**Conditions of development consent for the Sydney Metro Martin Place Station Precinct
SSD 9270 – North Site**

Condition B5, B6 and B7 discharge request #3 – Design excellence and design integrity review

**SYDNEY METRO - MARTIN PLACE
SOUTH ELEVATION
GENERAL ARRANGEMENT**

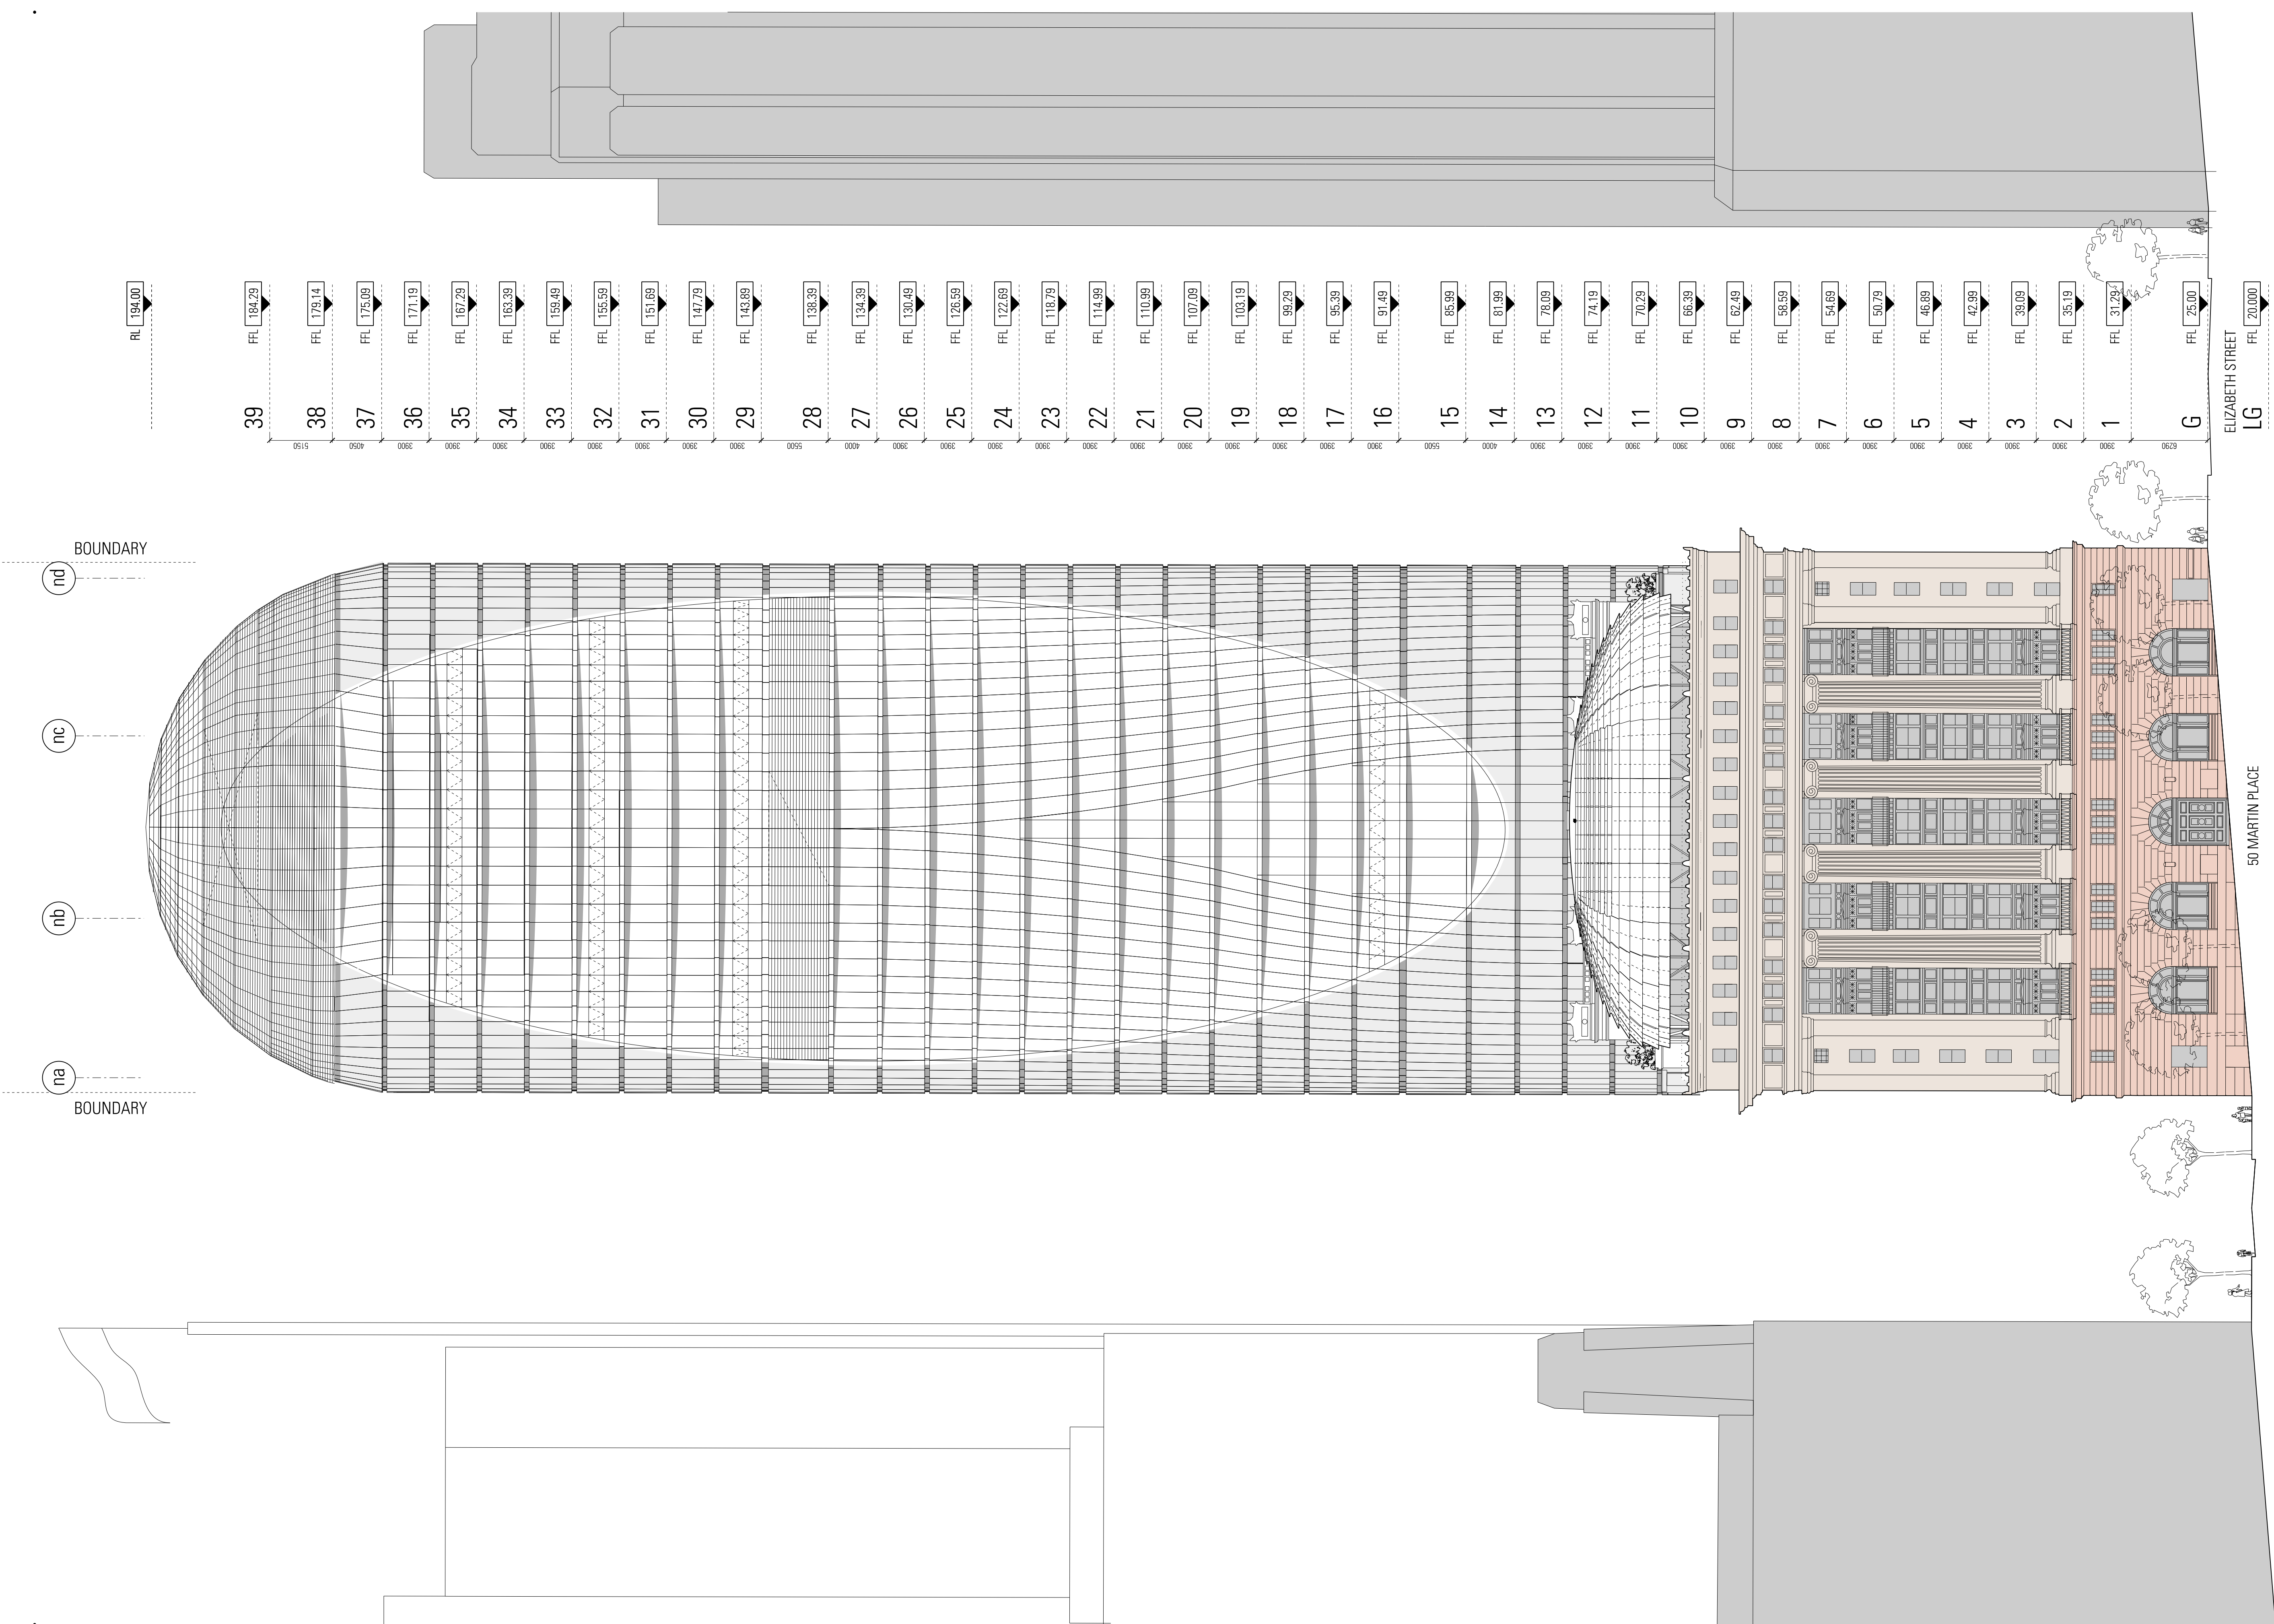
Accordingly, this letter is prepared in accordance with Condition B5 and sets out a proposed design change to the approved BMU openings for the North Site, located on Level 28 and the upper roof level of the southern facade. The proposed change seeks only to reduce the size of the BMU openings (maintaining the approved positions and design), and is the result of the design development / construction certificate drawing process. The minor design change is considered positive, reducing the extent of the required openings only.

This letter is accompanied by a comparison of the approved BMU openings (**Attachment A**), showing the approved BMU openings on Level 28 and the upper roof level in **red**, and the proposed BMU openings in **black**. **Figure 1** and **Figure 2** are extracts of the drawing in **Attachment A**, providing a comparison of the existing and proposed BMU openings on Level 28 and the upper roof of the southern façade of the North Site tower.

The proposed change is not required to be reviewed by the OSD DRP as it will not impact upon the design excellence qualities of the approved building. OSD DRP review is not considered necessary on the basis the proposed change is minor and will make the BMU openings less visible. The modification will have a positive impact on the overall southern façade design.
